From: Michael Eastham <Michael.Eastham@arun.gov.uk>
Sent: 28 January 2020 15:31
To: Planning.Responses <Planning.Responses@arun.gov.uk>
Subject: FW: A/122/19/OUT - Land off Arundel Road, Angmering - Development Framework Plan

I have viewed the revised layout plan A/122/19/OUT.

Please find attached the revised Layout Plan for A/122/19/OUT - Land off Arundel Road, Angmering.

Figure 5.1: Development Framework Plan.

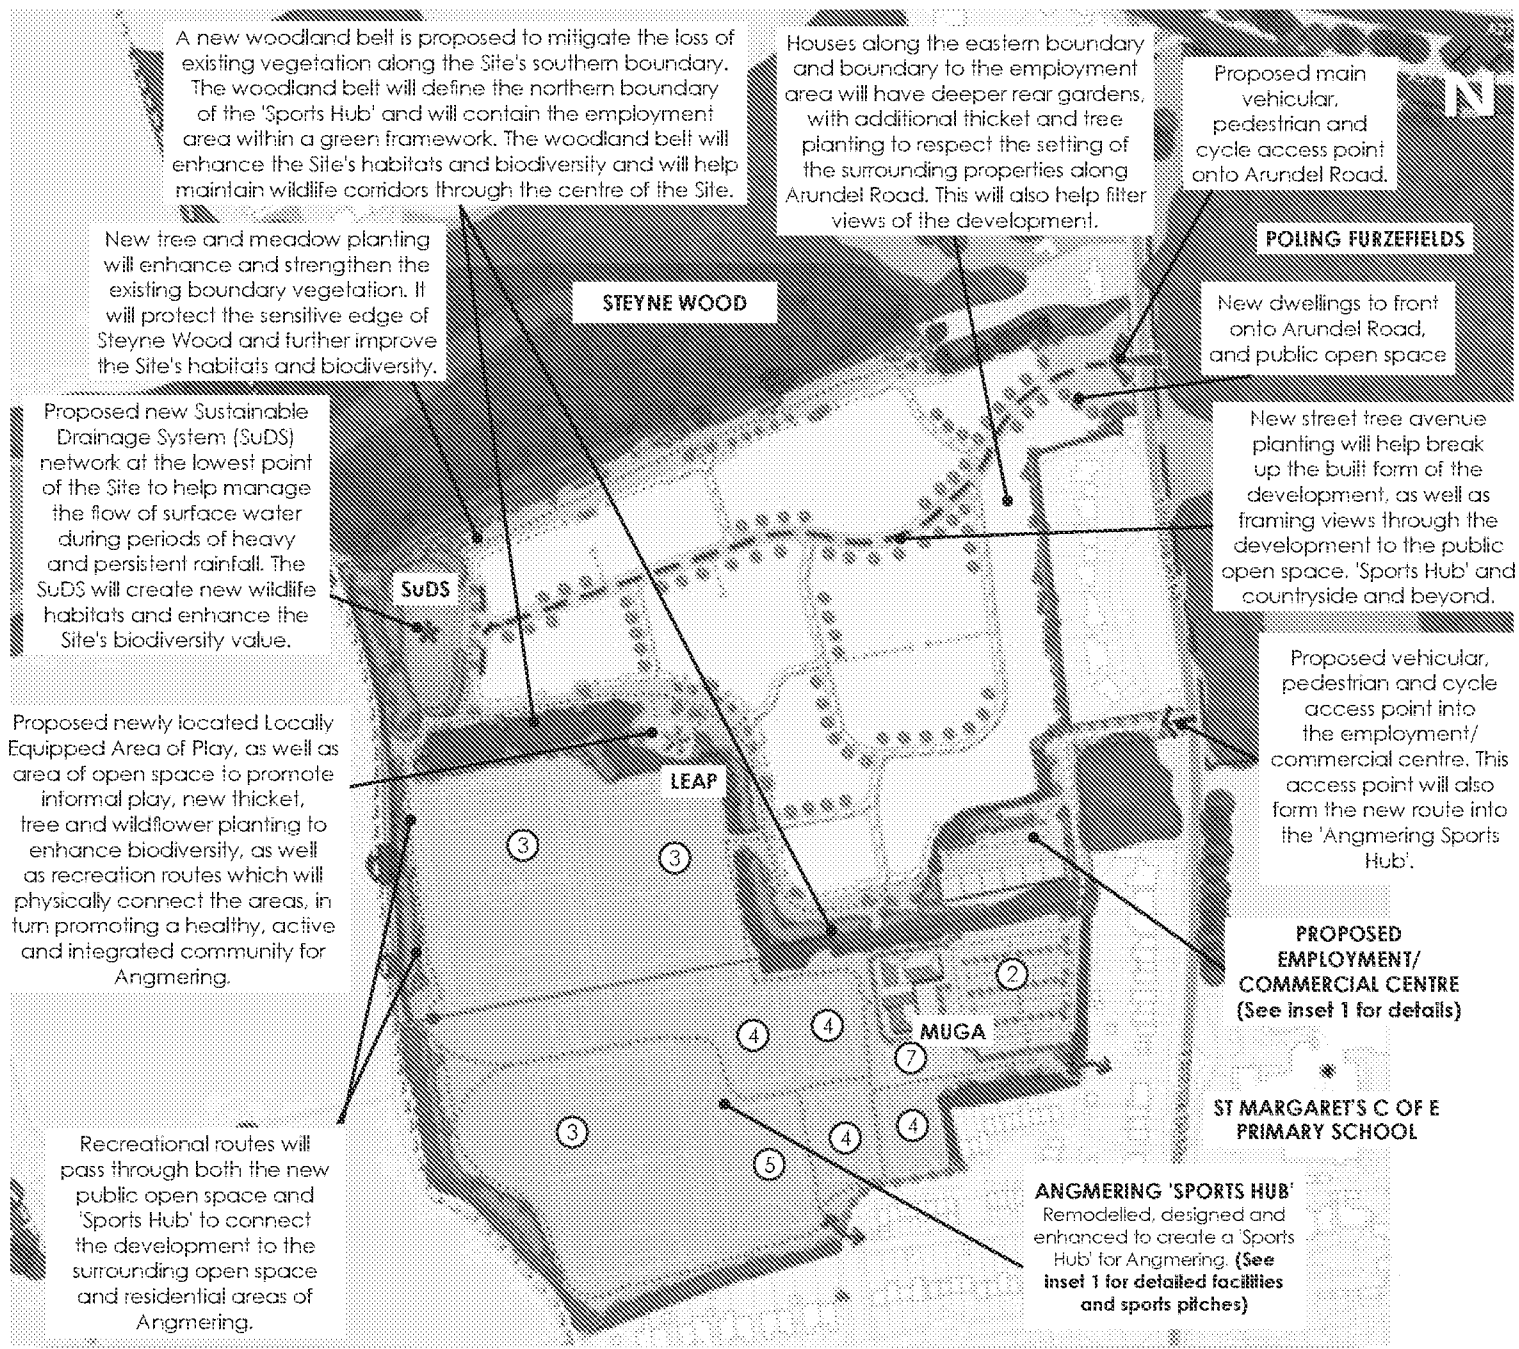
The new proposed location of the LAP is much more central, easily assessable and convenient for the whole development. It is located well away from the main access road into the estate and from the away from Arundel Road which carries a greater volume of traffic to the nearby A27 trunk road. The previous location presented possible dangers of conflicts with traffic on the access road or for a person with criminal intent to snatch a child without entering the development.

The new LAP location makes it more difficult for anyone to reach the LAP by car or to make a quick escape without being noticed. The risk for potential offenders are higher.

It is well overlooked all around from surrounding housing and is still close to the LEAP should children wish to progress with supervision across to the LEAP.

The small areas of surrounding planting should provide sufficient distance so as not to cause conflict with noise for the nearest dwellings, although there may be slightly more movement of people in the adjacent roads.

My recommendations for a surrounding 1or 1.5m Metre high perimeter fence (such as bow topped railings to not restrict surveillance) with gated entrance would still apply and help to deter crime & criminal damage and keep dogs out.

I consider this to be a much safer location than previously indicated.
